TO: New Home
ATTN: Steven Kirby
PROJECT #: 21-2780-B (31-WB)
PAGE: 1 of 1
DATE: October 4, 2023
LOCATION: 44 Willow Creek Place
PLAN REF: Lot 31 Woodbridge by New Home
 Project# 21-2780

THE FOLLOWING CHANGE(S) OR PROPOSED CHANGE(S) LISTED BELOW ARE DEVIATIONS OR CLARIFICATIONS FOR THE ABOVE REFERENCED PLANS:

OPT. FIREPLACE AT PATIO
SCALE: 1/8"=1'-0" ON 11x17, 1/4"=1'-0" ON 22x34

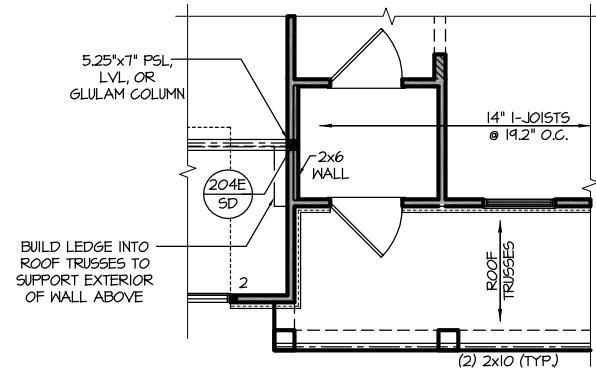
(3) 2X6 JACK STUDS AND
 SINGLE 2X6 KING STUD.
 ADDITIONAL 4 STUDS ADDED
 AT THE CORNER.

OPT. FIREPLACE AT PATIO
 SCALE: 1/8"=1'-0" ON 11x17, 1/4"=1'-0" ON 22x34
